**Tamworth Solar Farm (SSD-9264)  
Request for Additional Information**

I refer to the assessment of Tamworth Solar Farm (SSD-9264). After careful consideration, the Department is requesting that you provide additional information.

Date: 18.03.20		Scale: 1:250 A1		Designed: AS		Project No		
Cad Ref: HD284 OXLEY HIGHWAY INTERSECTION R5				HD284				
4	ADD BAR AND BUS BAY			AS	18.05.20		Drawing No	Revision
3	ADD BUS BAY			KU	28.04.20			
5	WIDEN BUS BAY			KU	22.05.20			
No	Amendment			Drawn	Date		INT02	5

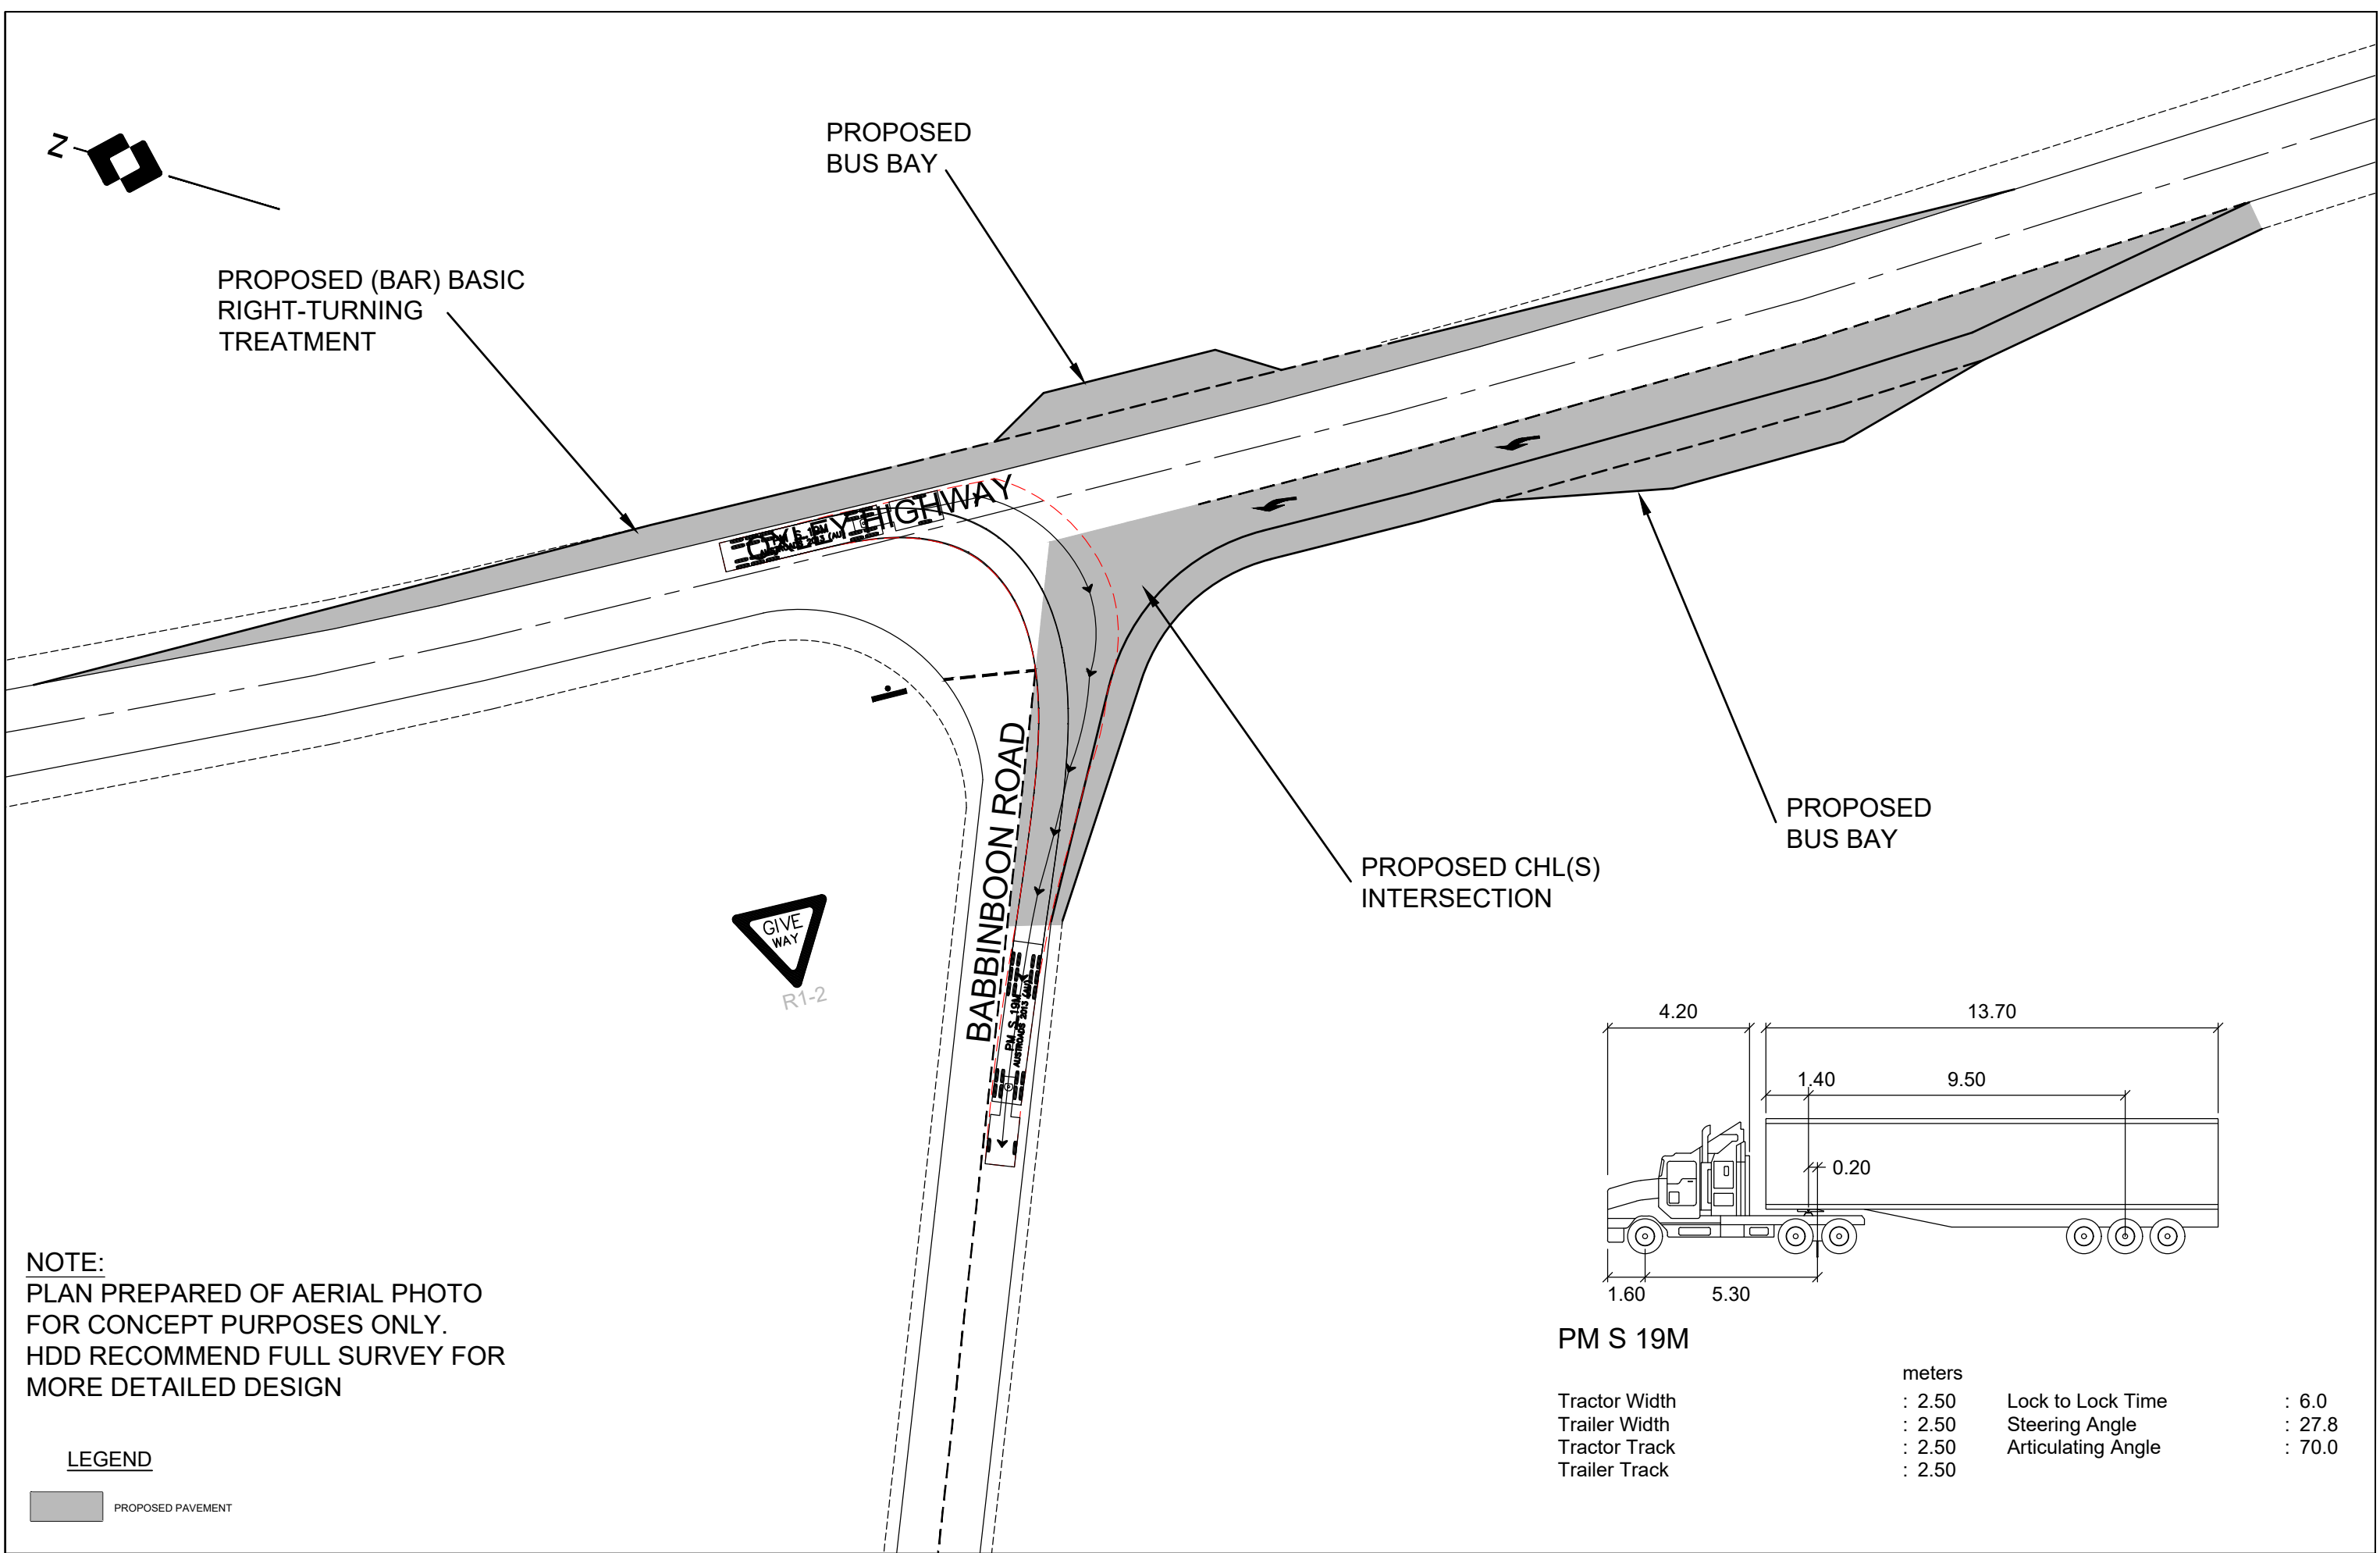
- **Road upgrades:**
  - clarify the nature and location(s) of the intersection upgrades and intersection treatment types and include a swept path diagram for the largest vehicles travelling to and from the site;
